In accordance with section 89E of the *Environmental Planning and Assessment Act 1979*, it is recommended that the Executive Director, Development Assessment Systems & Approvals:

- (a) **considers** the recommendations of this report for the staged development application including the concept proposal and Stage 1 construction enabling works for the Bega Valley Health Services Redevelopment (SSD 5307_2012);

Flood Levels with Development Footprint

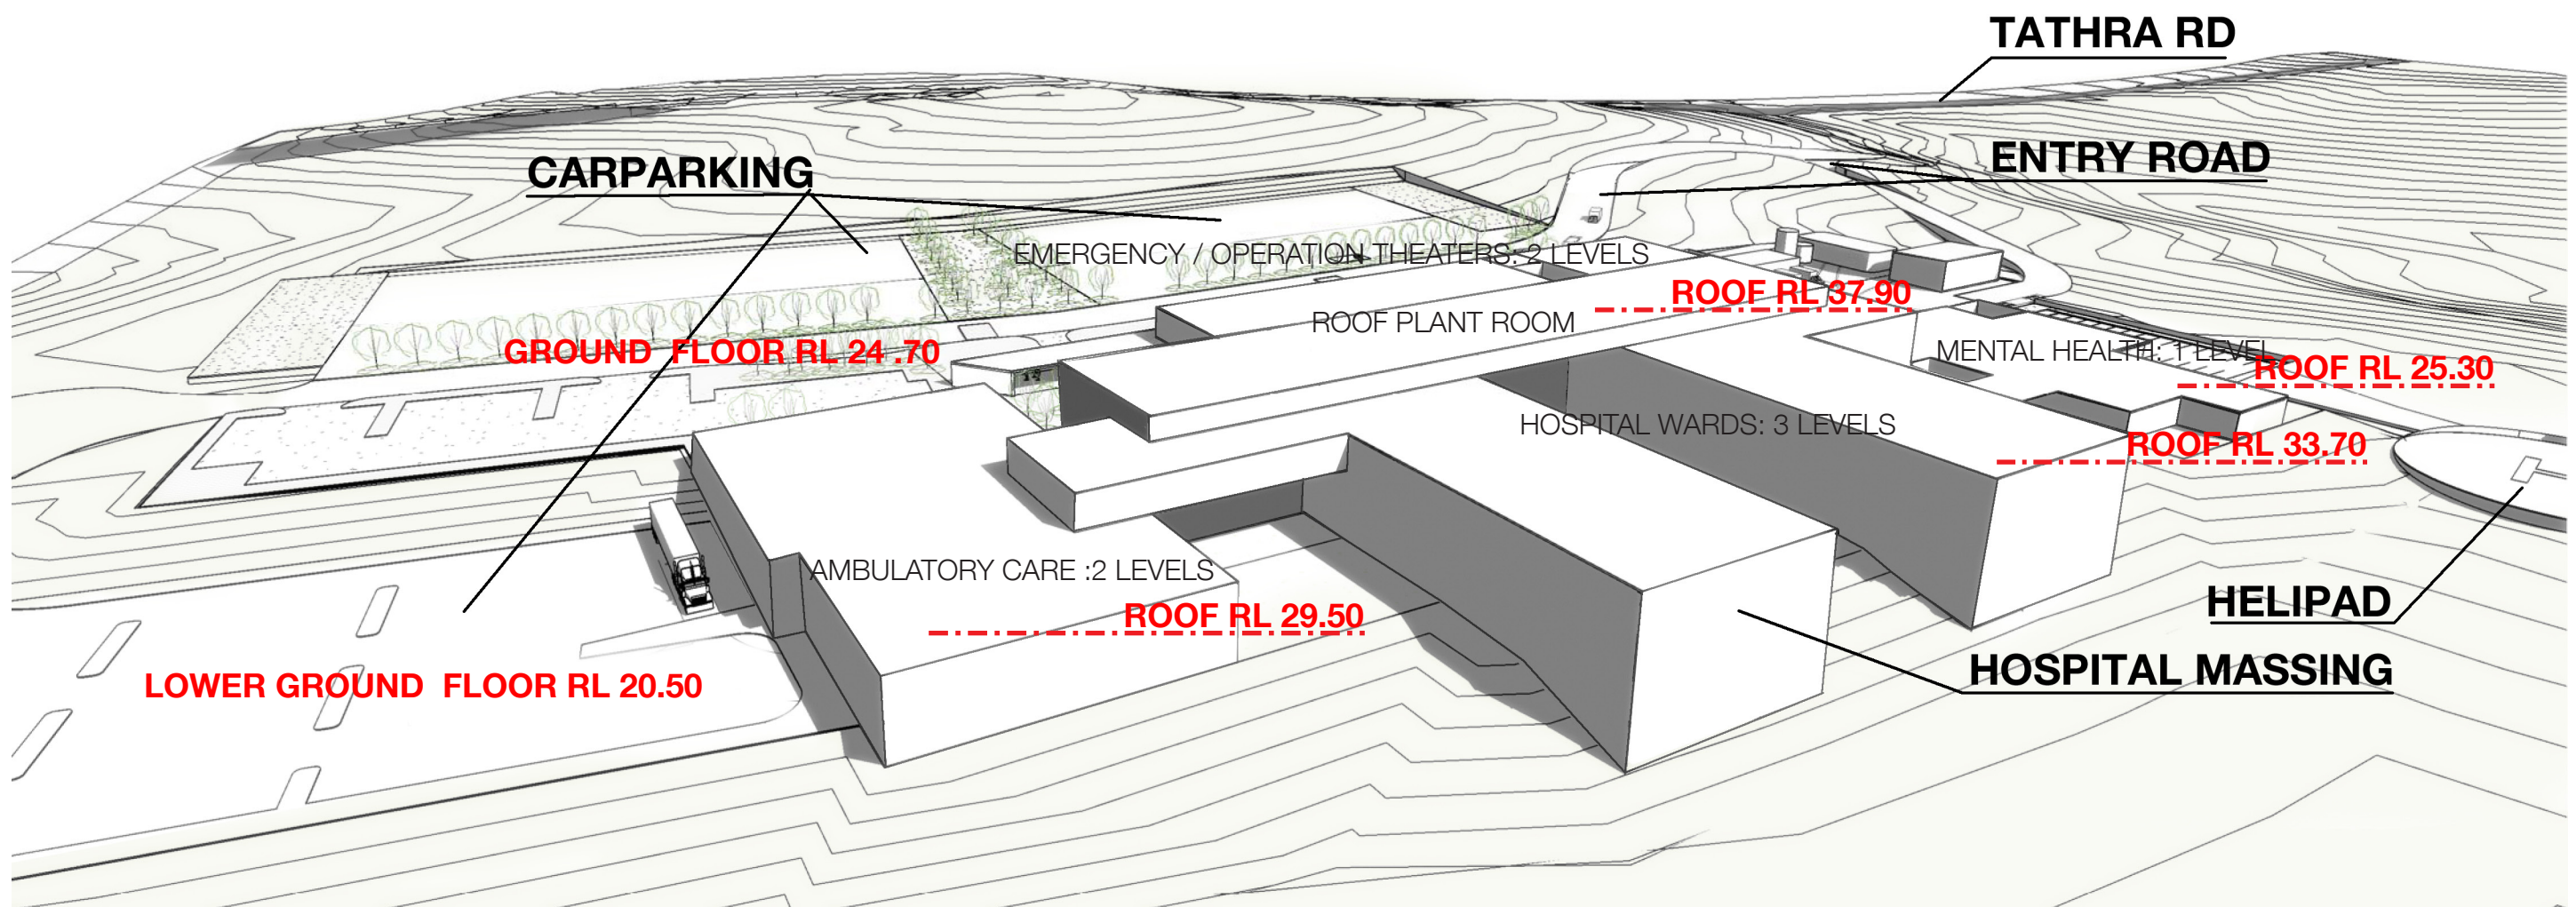
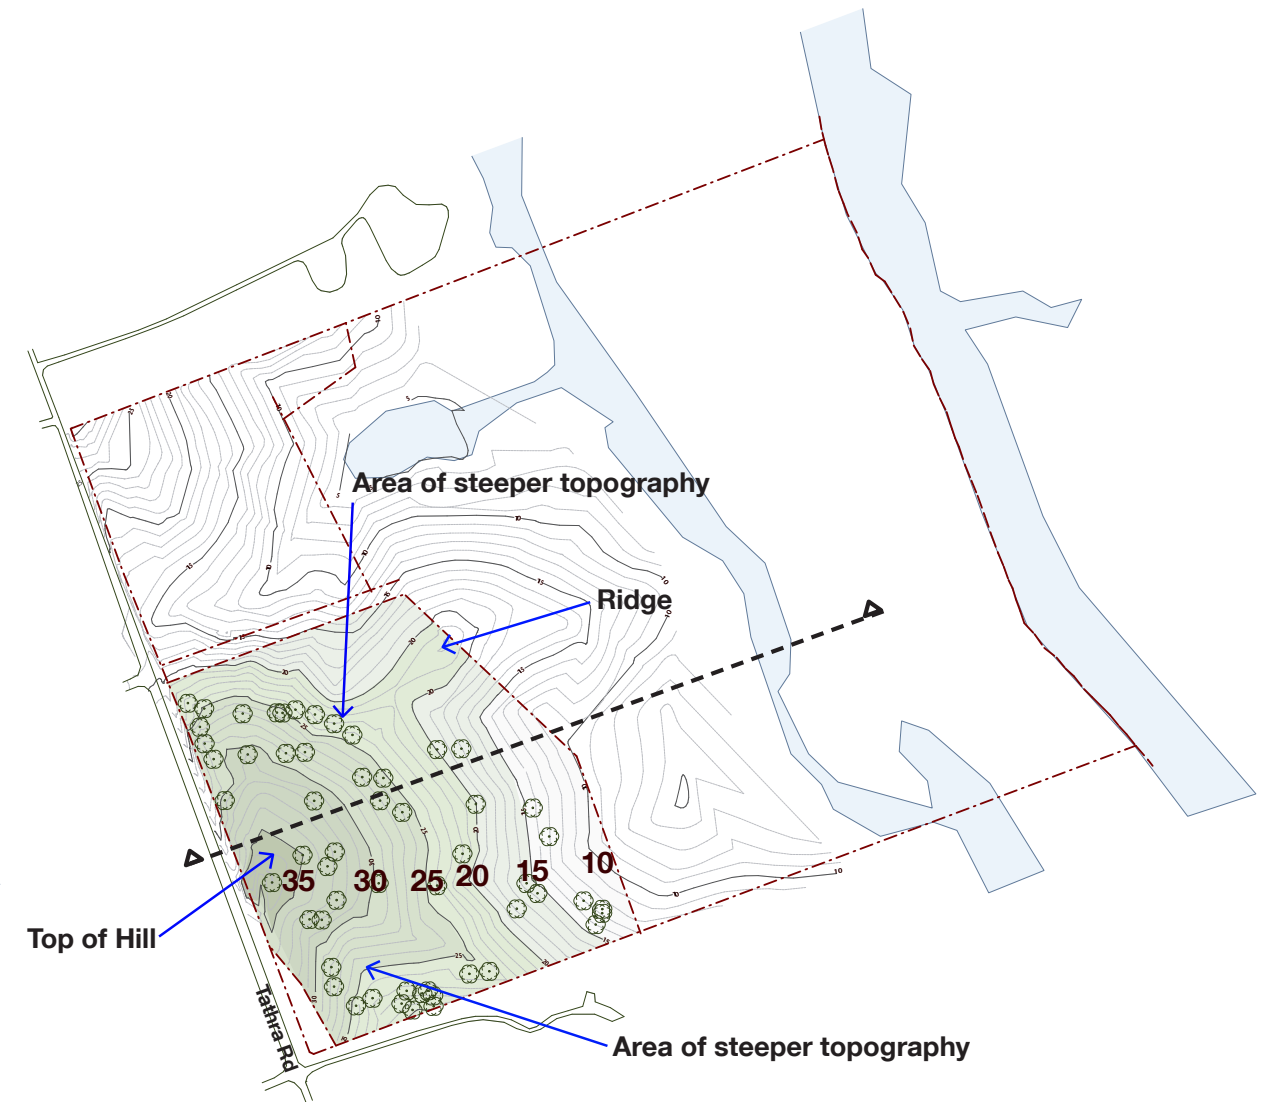
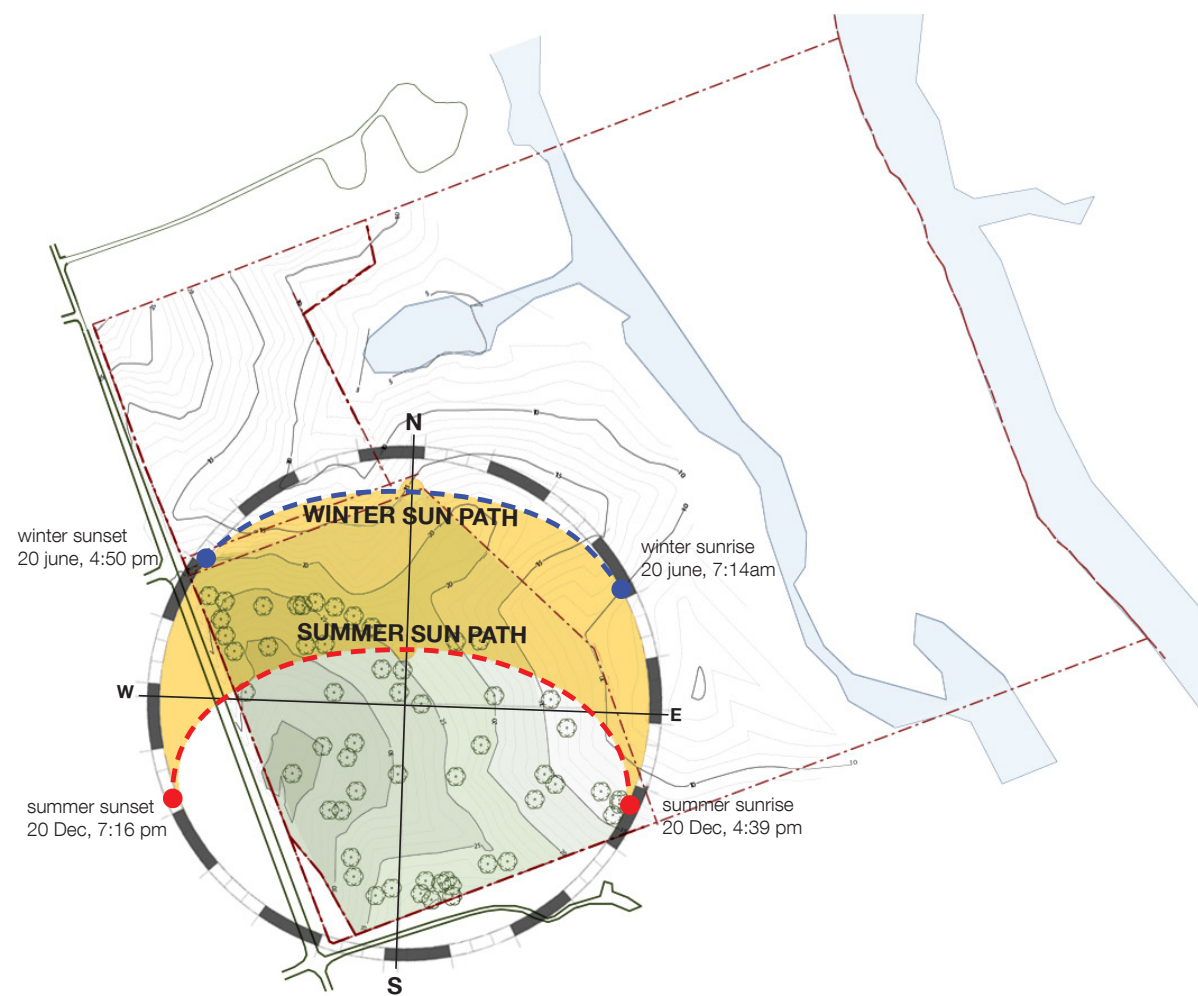
The Floodplain Risk Management Guidelines (including NSW Flood Plan Development Manual and Managing the Floodplain, Emergency Manual Australia, Manual 19), recommend that vulnerable development (ie hospitals) be located above the PMF level. Accordingly, the ARUP Flood Report concludes that the PMF should be adopted as the flood planning level for the site and furthermore, that an access route should be available to the hospital which will remain free of flooding, including during a PMF event. The ARUP Flood Report has recommended that a further comprehensive analysis of the flood risk to the site should be undertaken to confirm the most appropriate flood levels.

The department concurs with these recommendations and notes that the design levels for the western end of new Hospital Drive (where accessed off Tathra Road) will be below the PMF at approximately RL19.5 to RL 19.0. It is therefore appropriate that consideration be given to allowing for flood free access to the hospital site during a PMF event. The department has recommended an appropriate condition to address this matter.

- Prior to the issue of a section 109R certificate for commencement of the Stage 1 works, a comprehensive analysis of the flood risk to the site be undertaken to confirm the most appropriate flood levels for the site.
- a Hospital Emergency (Response and Evacuation) Plan be developed for the site taking into account various flood scenarios which may restrict or cut-off access to the site, result in inundation of low lying parts of the site and extended periods of isolation. It is recommended that the Plan also consider the transfer of equipment and patients to other hospitals.
- An alternative access route be considered in the Stage 2 site planning which will allow the hospital to remain free of flooding, including during a PMF event.

**Figure 8: Proposed Helicopter Flight Paths (source: BVN Architecture)**

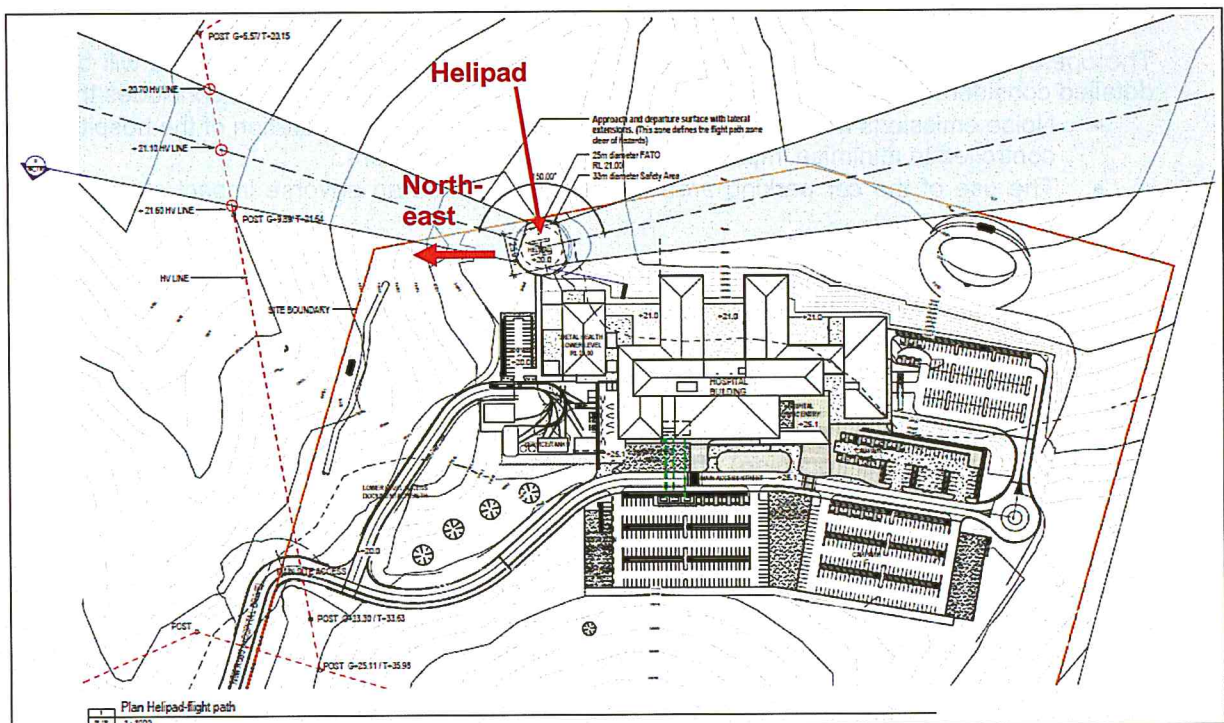
Council has suggested that the location for the helipad should be reviewed to ensure that the location of the flight path is further to the north-east mainly across agricultural land.

The flight path as illustrated in the **Figure 8** shows that the helicopter's arrival and departure paths would be over the neighbouring agricultural land. A minor movement of the helicopter landing pad further to the north-east would result in minimal change to neighbouring agricultural land. On balance and having considered the anticipated low level of usage, the department finds the proposed location for the helipad to be acceptable.
